Our Reference: SYD20/00773/03
Departments Reference: SSD-10479

EXHIBITION OF EIS - 106-228 ALDINGTON ROAD - KEMPS CREEK

The documentation, including *AsonGroup Transport Assessment Report* (TAR), in support of the proposal has been reviewed and comments and recommendations are provided in **Attachment A**.

Drawing No. 19-609-C1133	Project No. 19-609	Issue A
------------------------------------	------------------------------	-------------------

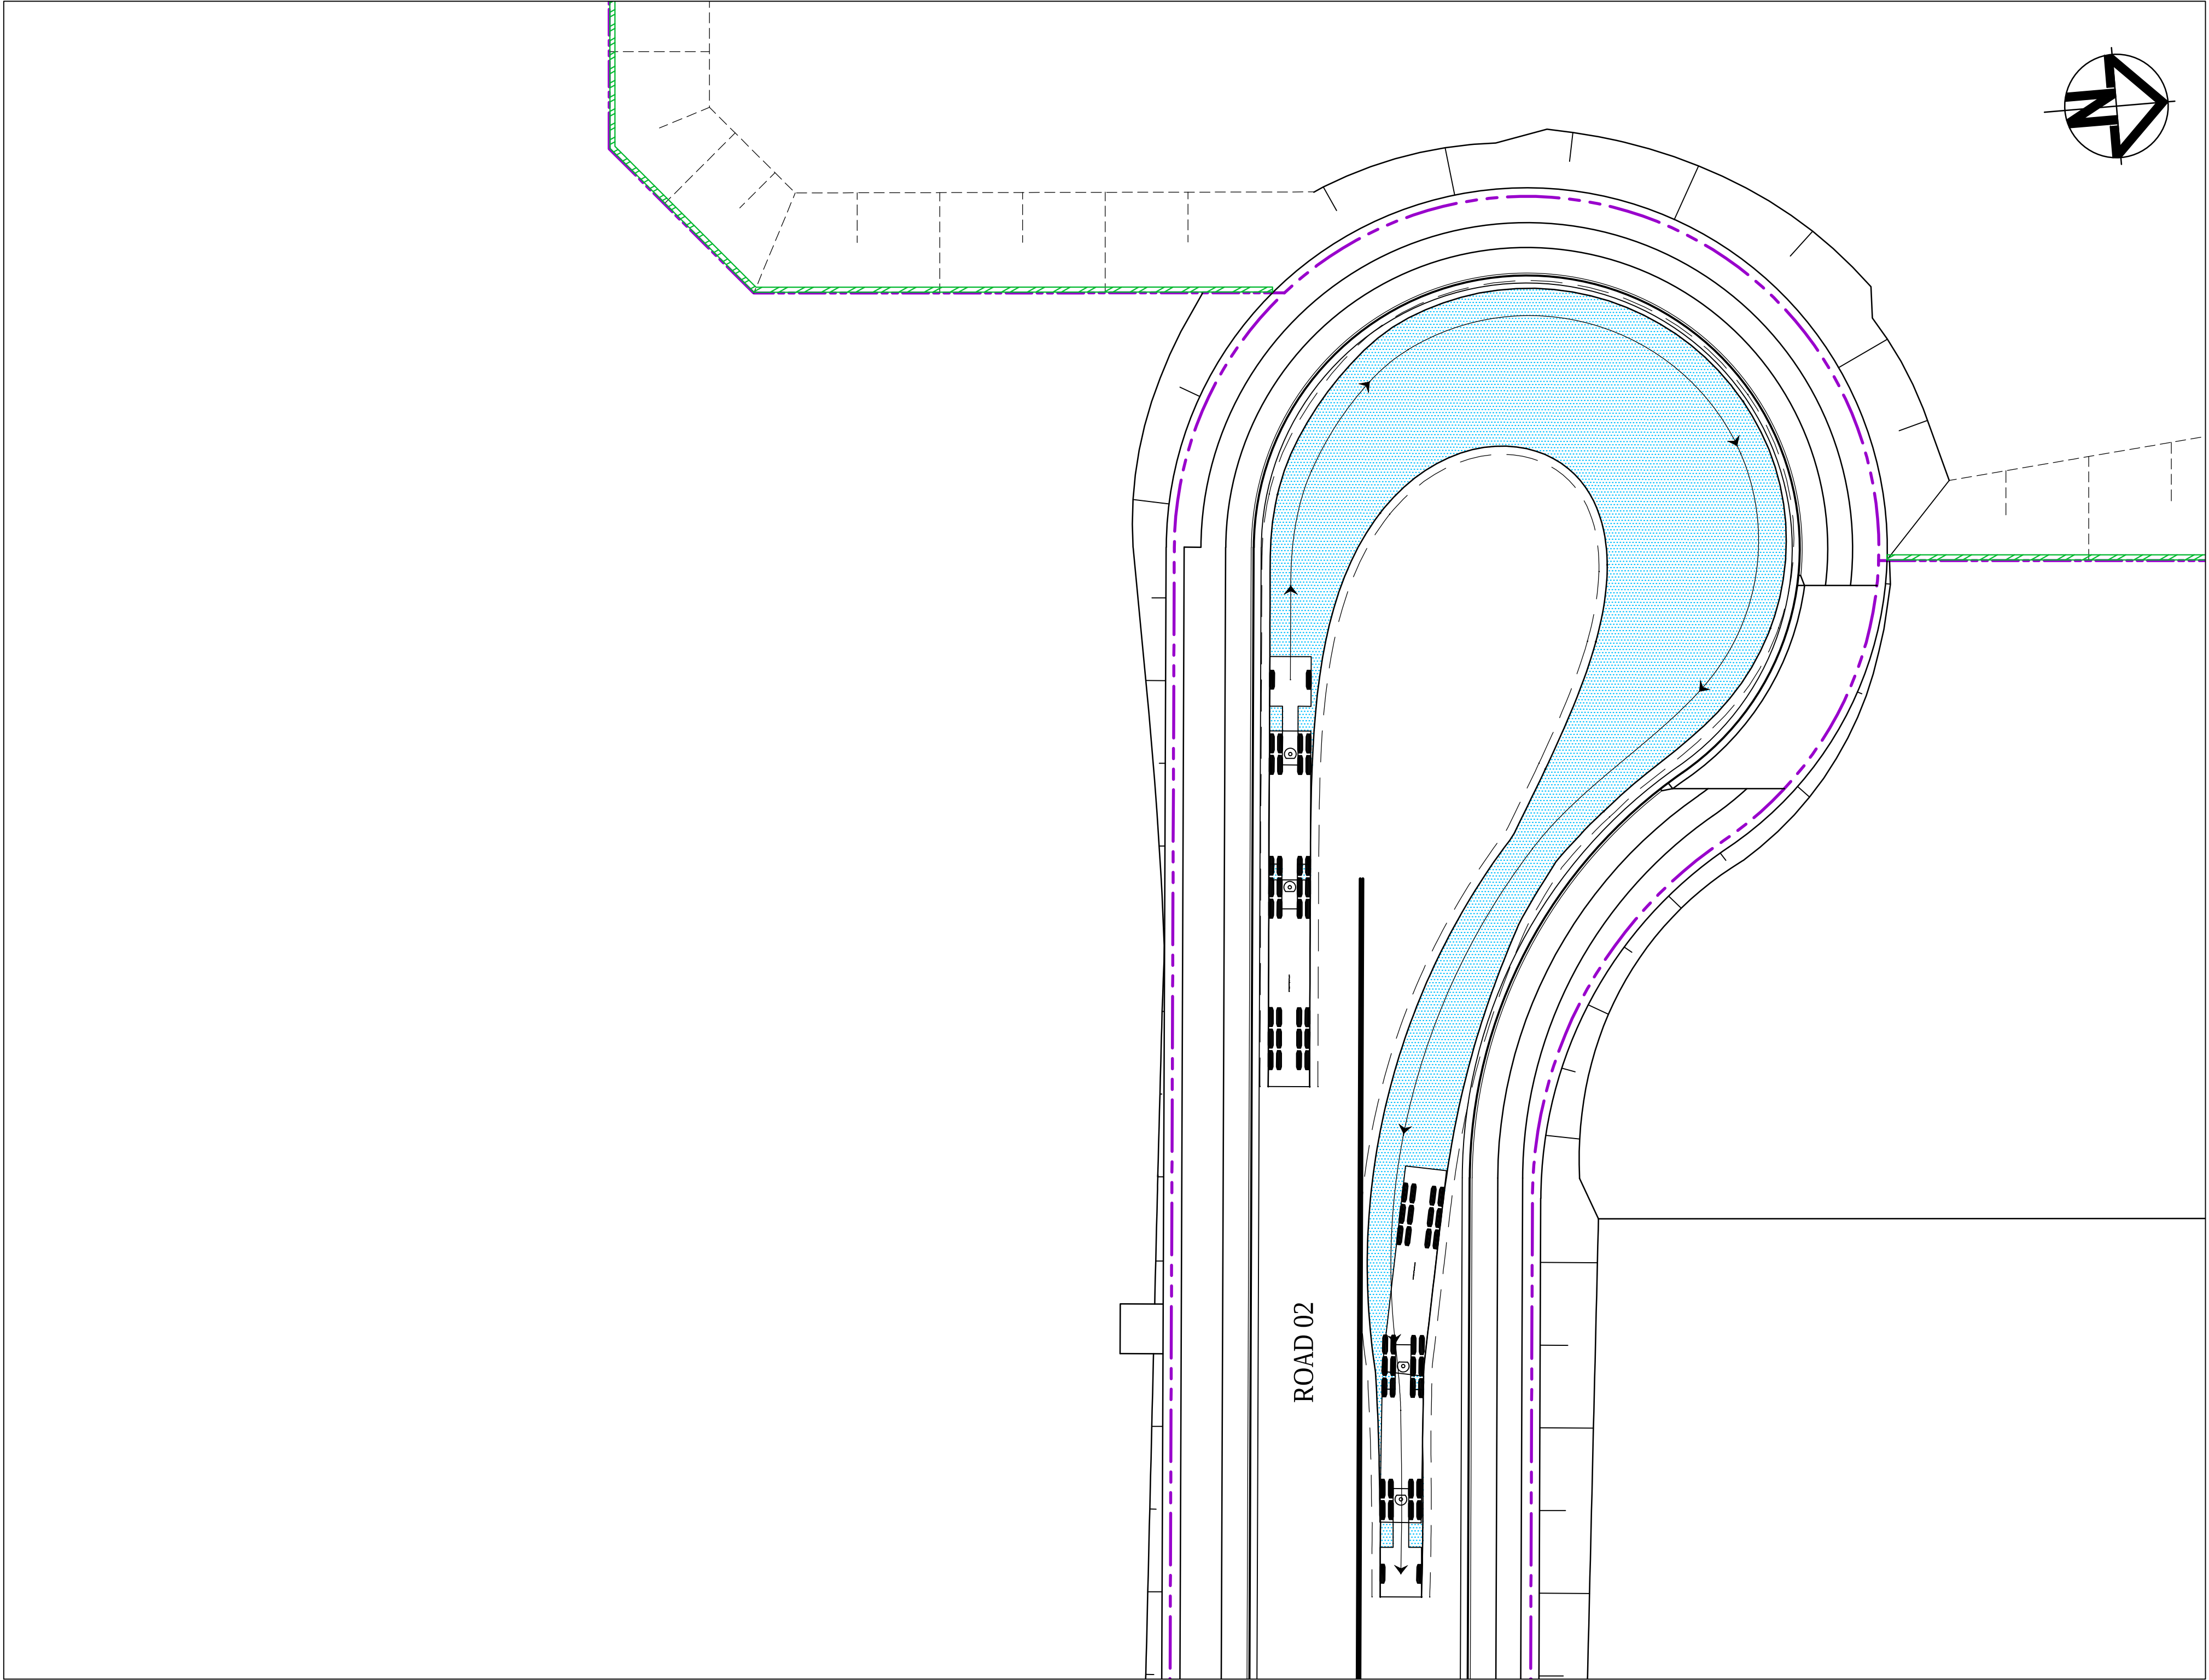
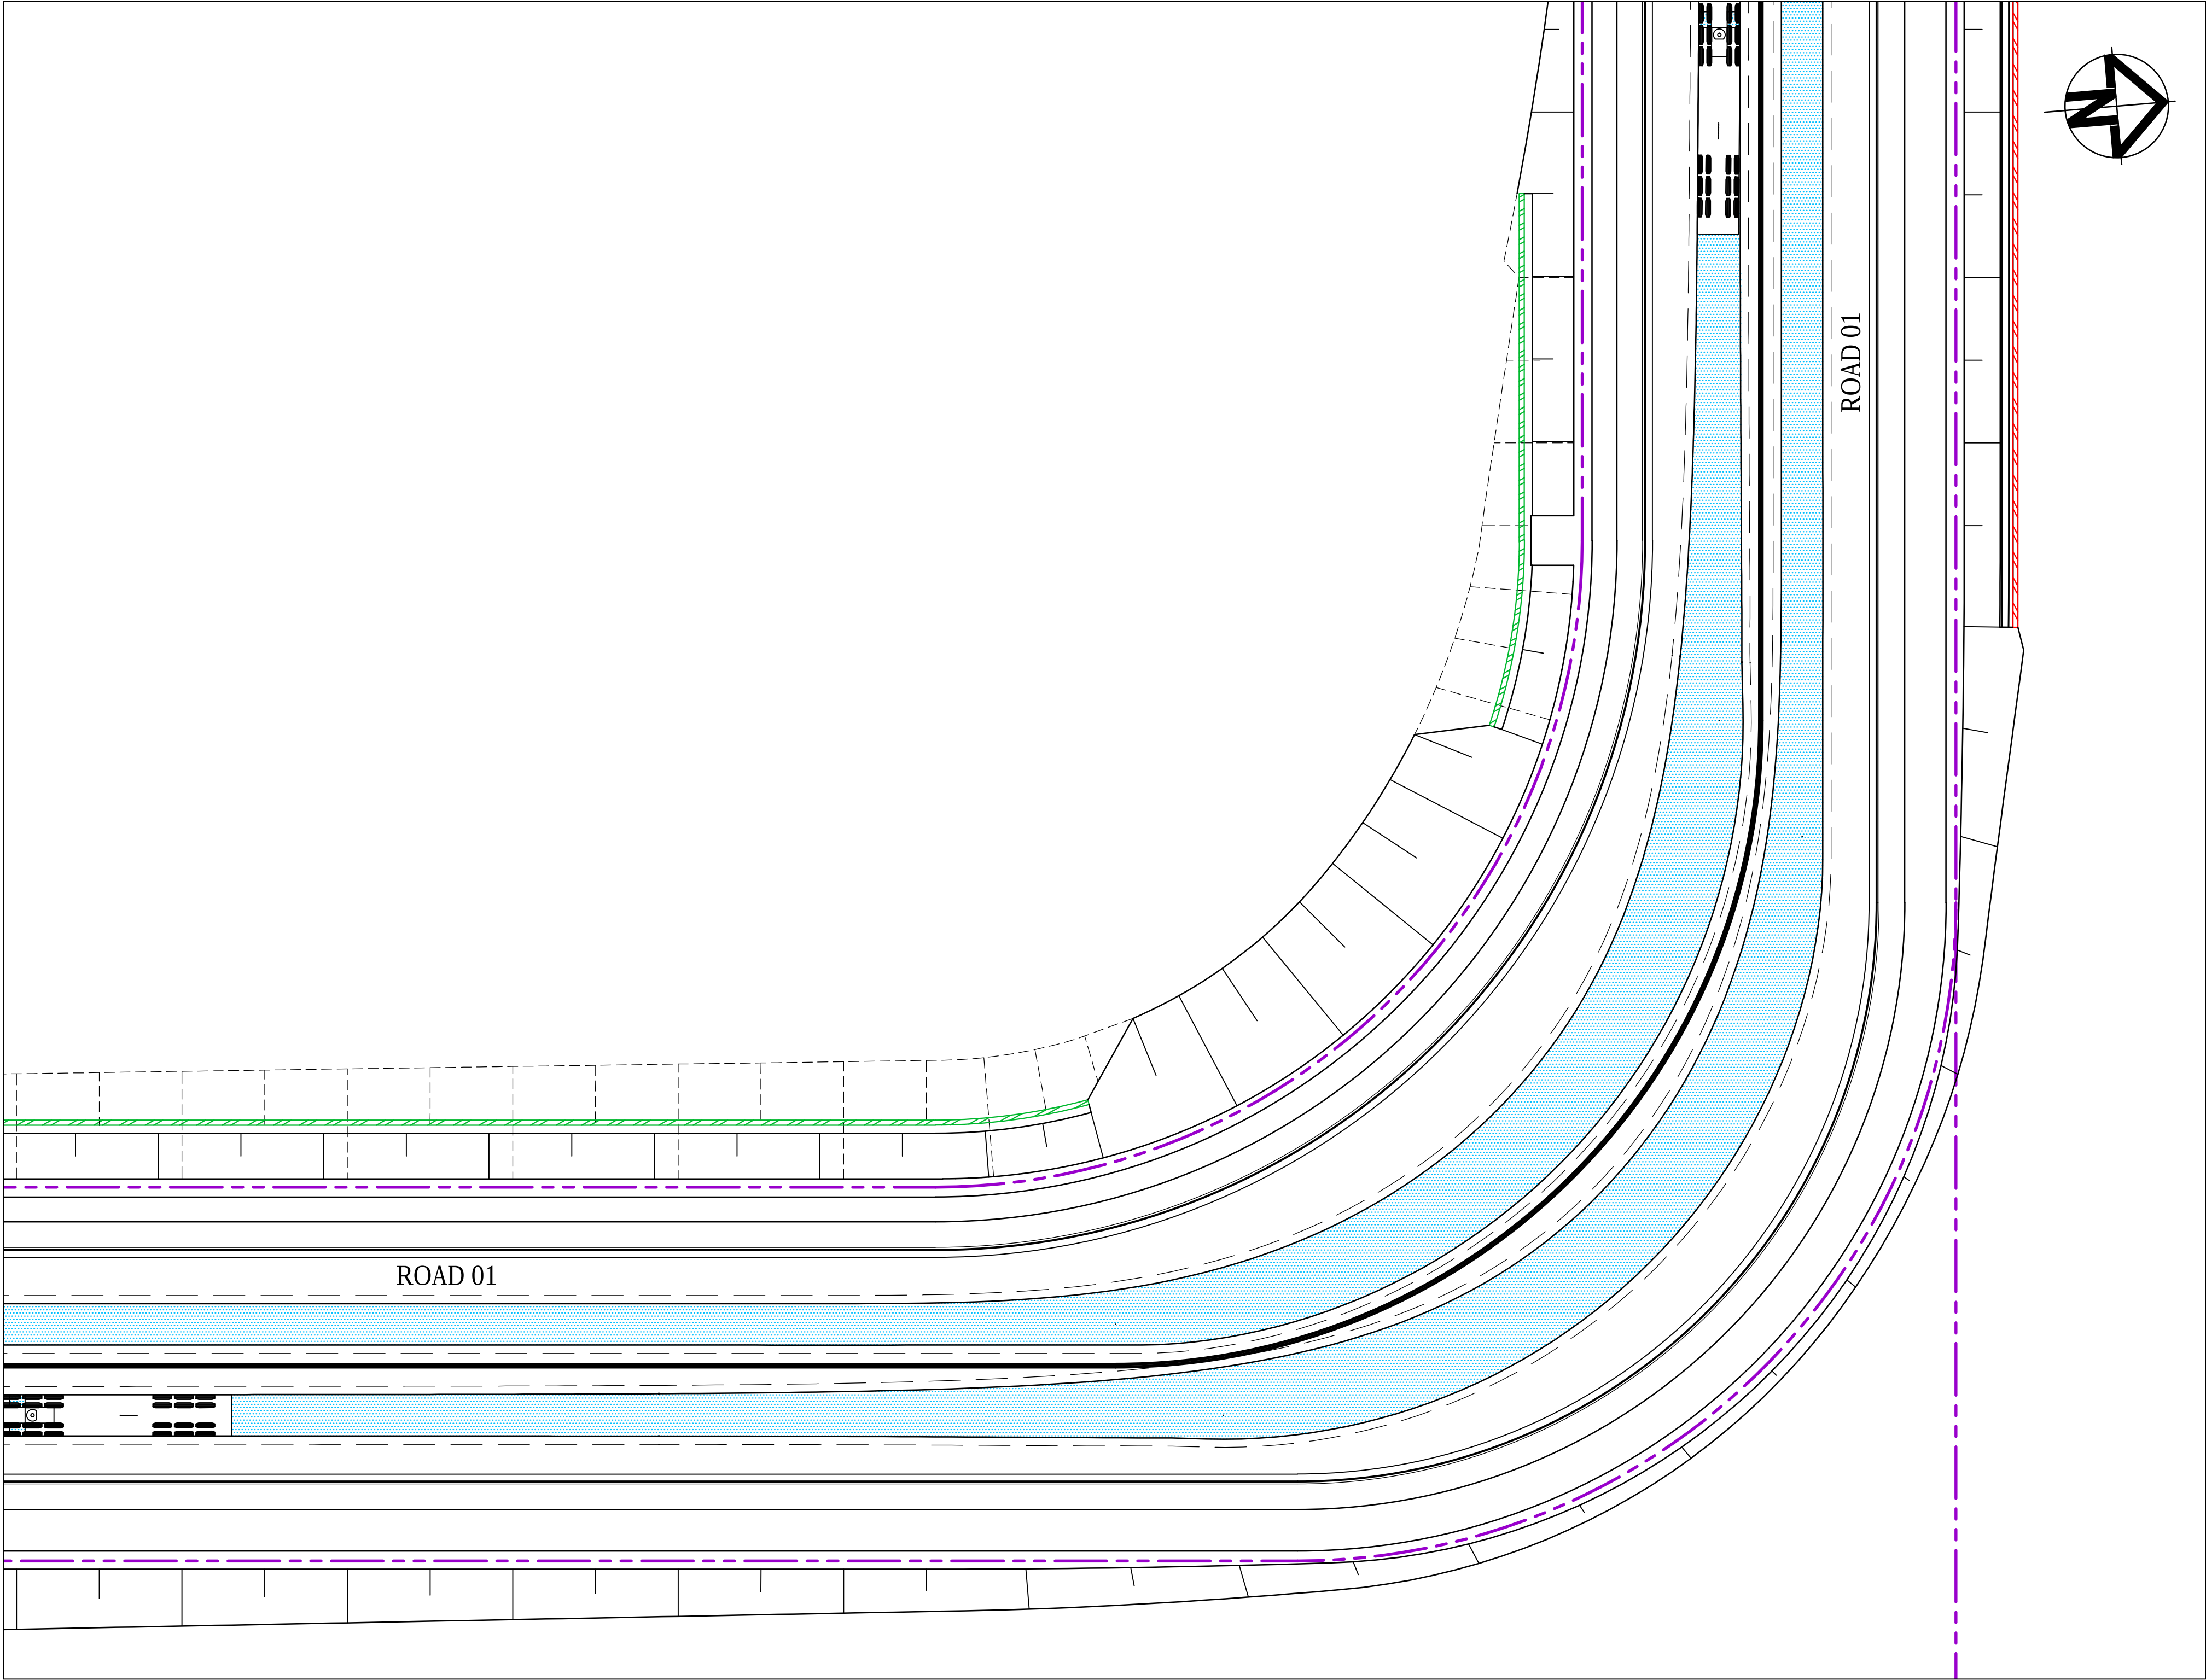
- d. Appendix B - the SIDRA results for the signalised intersection on Mamre Road/Abbotts Road show 80 seconds as the cycle time. The cycle times of all intersections should be modelled as a worst case scenario, this is achieved by using the maximum cycle time for the intersection. In this regard the model should be updated to use the correct maximum cycle time of 140 seconds.
- e. Appendix C - The swept paths provided are of an articulated vehicle (19m). Swept paths will be required to be provided to accommodate the largest type of heavy vehicle which could reasonably be expected to service the site. The WSEA SEPP outlines the required vehicle lengths to be accommodated for.

In this regard, the design vehicle for the access to the site should be assessed with a 26m B-Double and a 30m PBS 2B vehicle. In addition, all swept paths are to be provided including the roundabouts.

TfNSW requests the abovementioned information to be addressed/provided for further assessment prior to the determination of the application. TfNSW will further review and provide response upon receipt of the additional information.
